Marine Management Organisation

MMO Reference: DCO/2016/00003
Planning Inspectorate Reference:
EN010084
Identification Number: 20012636

06 June 2019

Planning Act 2008, Vattenfall Wind Power Limited, Proposed Thanet Extension Offshore Wind Farm

Figure 4-3 Contour plot showing the modelled unweighted SPL_{peak} values for installing a monopile using a maximum blow energy of 5000 kJ at the East modelling location

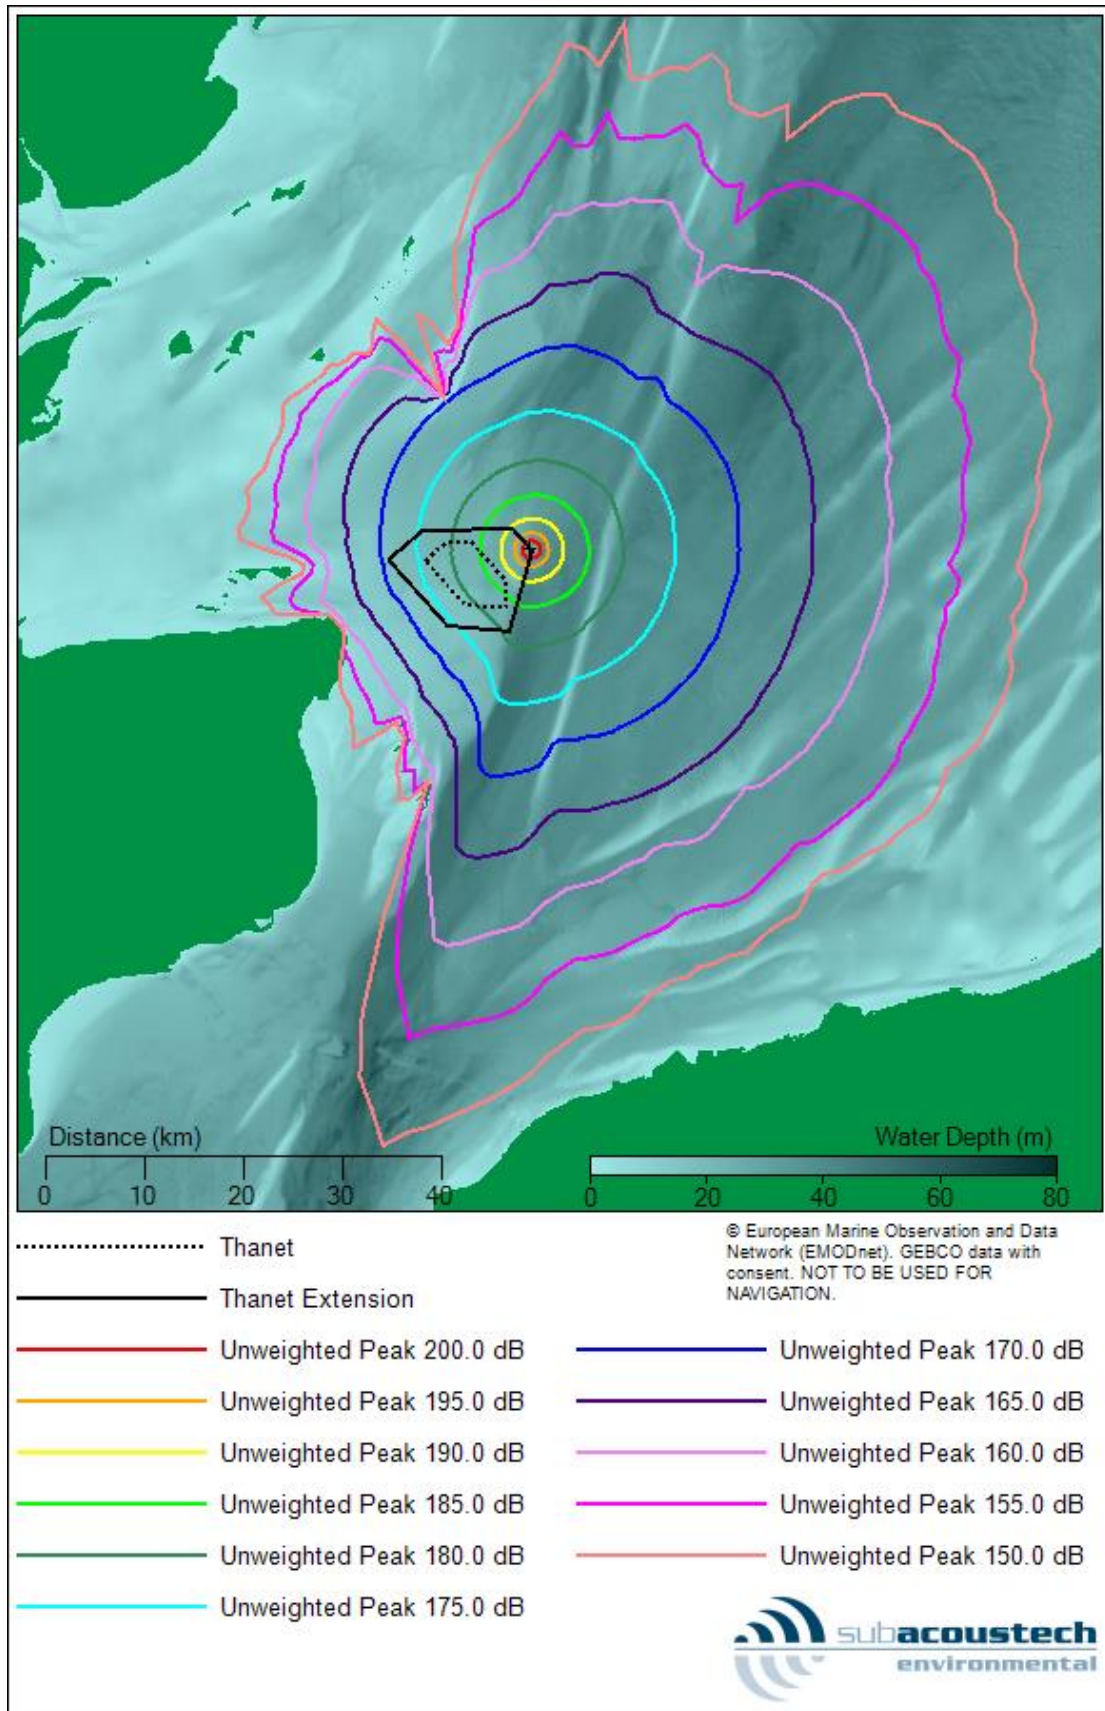
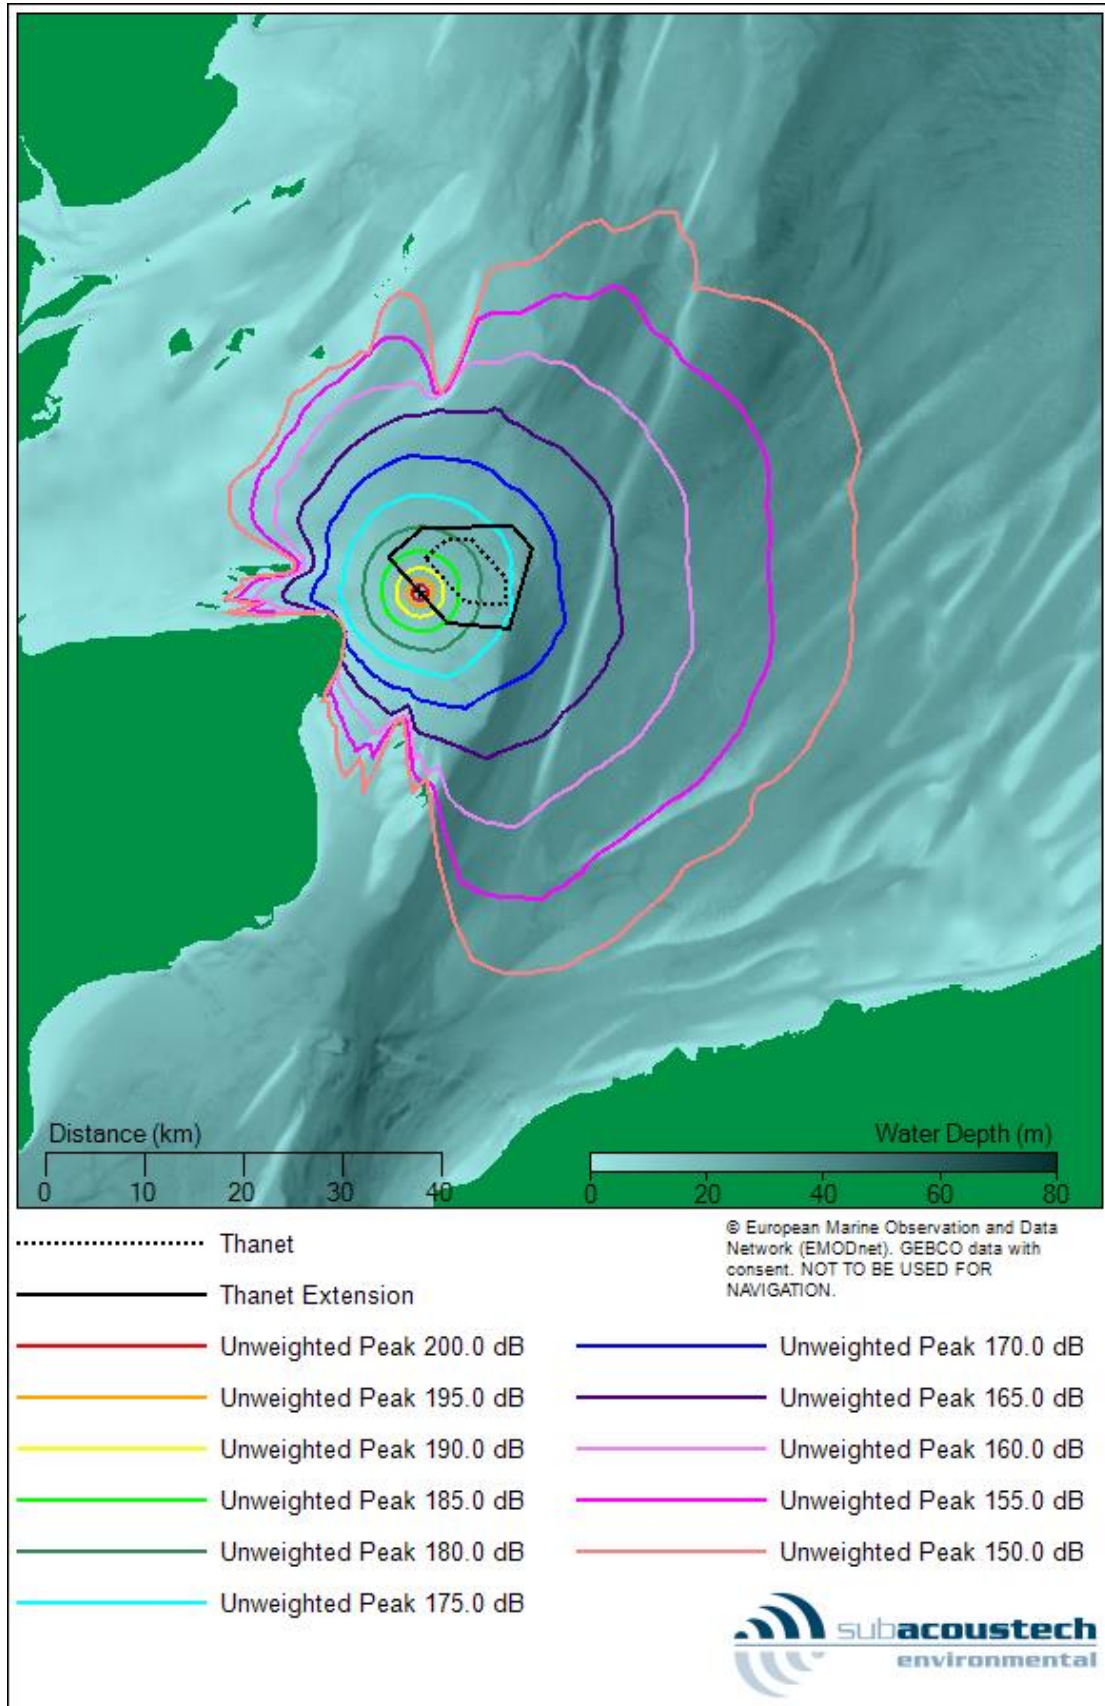
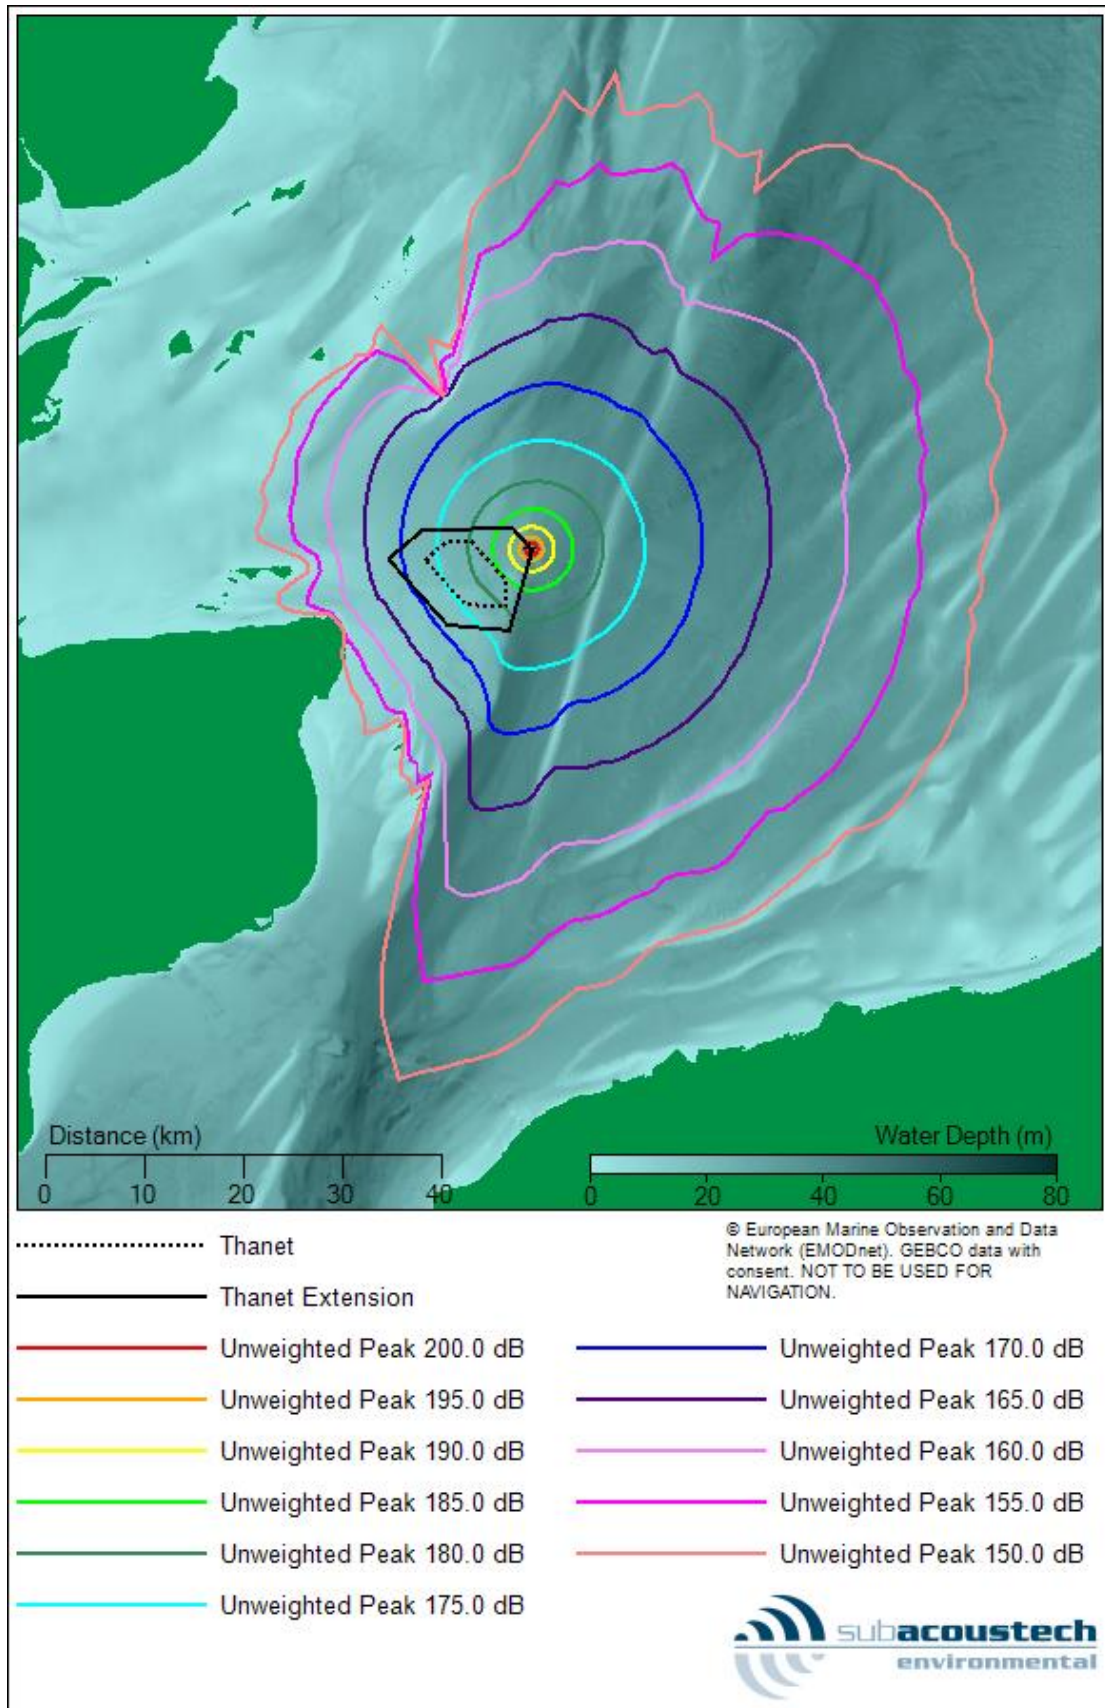
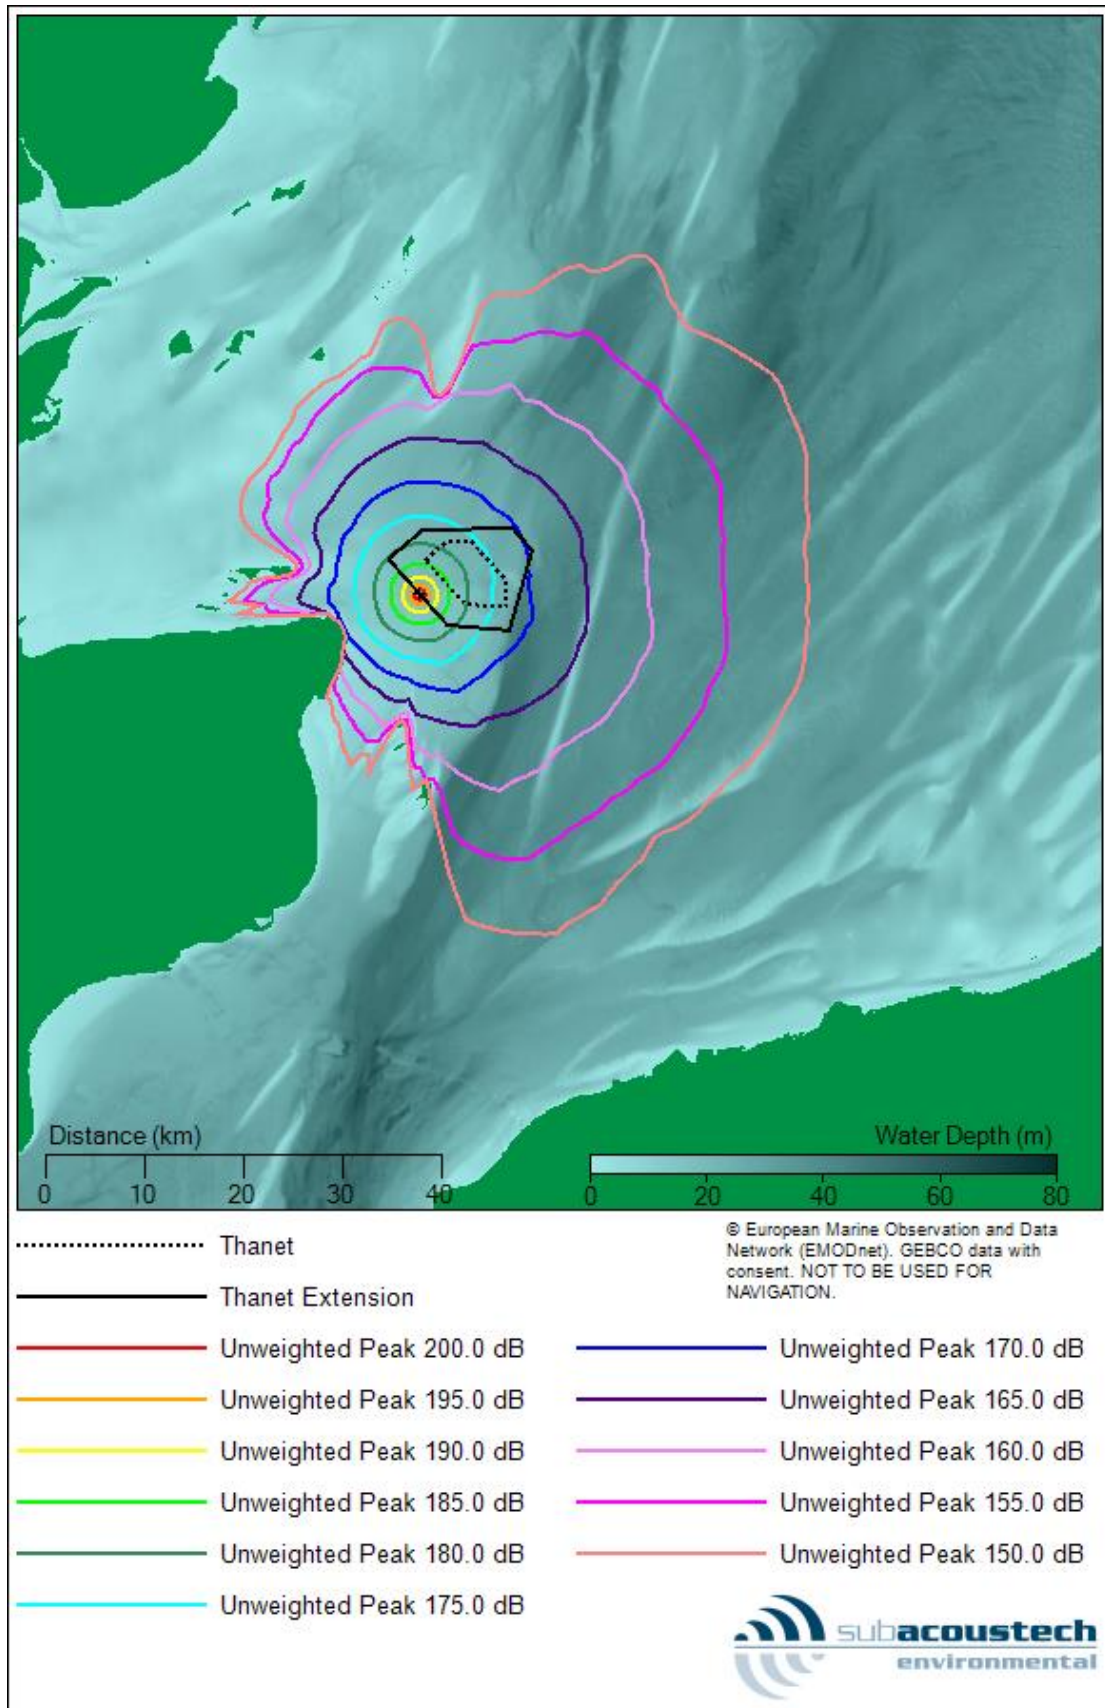
2.2.8 Figures 4-3 (Appendix A) and 4-4 of Annex 6-3 show contour plots for the modelled unweighted SPL_{peak} values for installing a monopile using a hammer energy of 5,000 kJ, for the East and South West locations respectively. Figures 4-5 and 4-6 show the SPL_{peak} contours for installing pin piles with the lower hammer energy of 2,700 kJ. **However, these maps should show the spawning grounds/International Herring Larvae Survey (IHLS) data, so it is clear what noise levels spawning herring are predicted to be exposed to.**

necessary for the Thames stock. Essentially, the MMO requires sight of either the modelled SPLpeak or SELss noise isopleths overlaid onto herring spawning grounds/appropriate IHLS data for the two modelled locations, in order to make an informed judgement on the potential risk of behavioural effects on spawning herring. Based on the evidence submitted by the Applicant to date, it is currently difficult to ascertain what the predicted noise levels will be at the spawning grounds. In the circumstances, the MMO must adopt a precautionary approach and maintain that the proposed restrictions are fully justified.

Figure A 5 Contour plot showing the impact ranges for harbour porpoise (Lucke et al., 2009) at the east location for installing a monopile with a maximum blow energy of 5000 kJ

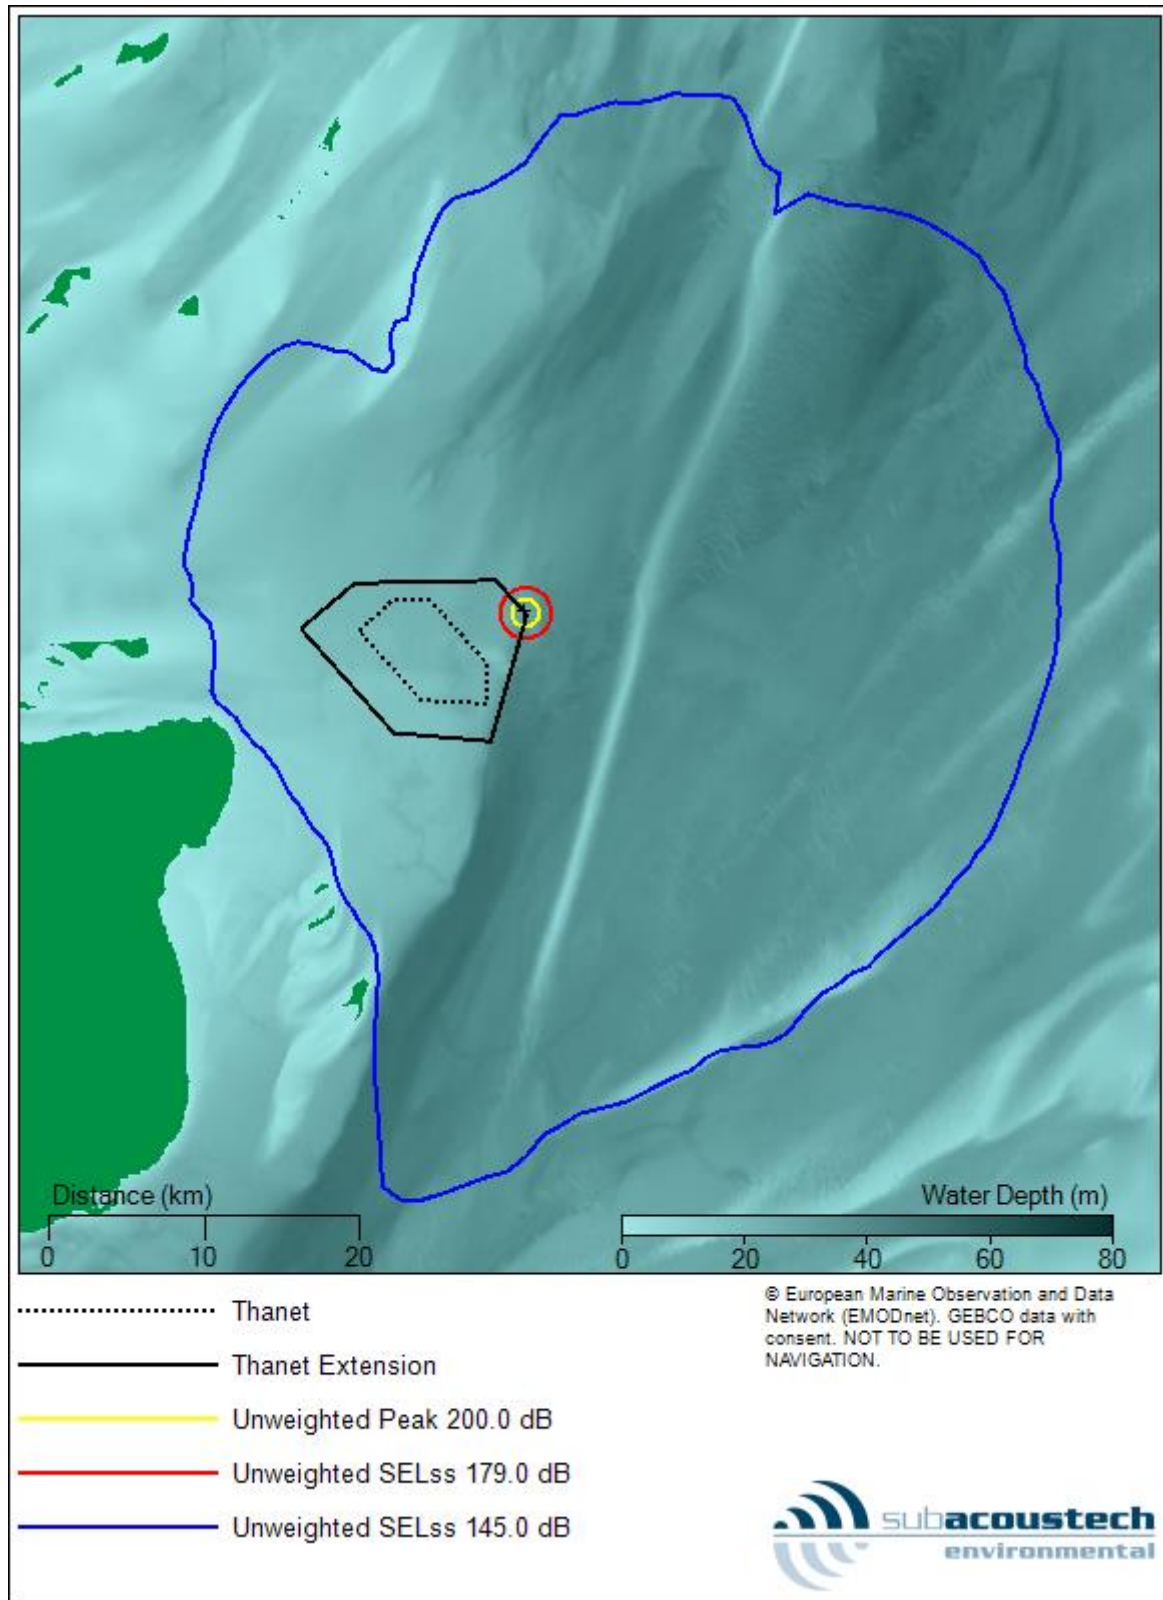
2.2.10 The MMO acknowledge that some figures showing SELss contours have been provided in Annex 6-3. However, the SELss contour plots the Applicant is referring to relate to various (and limited) SELss thresholds based on marine mammal noise exposure criteria (i.e. see Figure A5 in Appendix A showing the 179 dB and 145 dB SELss contours). **As above, the herring spawning grounds should be clearly shown. To fully assess impact the Applicant should provide a figure (similar to Figure 4-3) of the modelled incremental SELss isopleths/contours, which include the noise levels at the herring spawning grounds.**
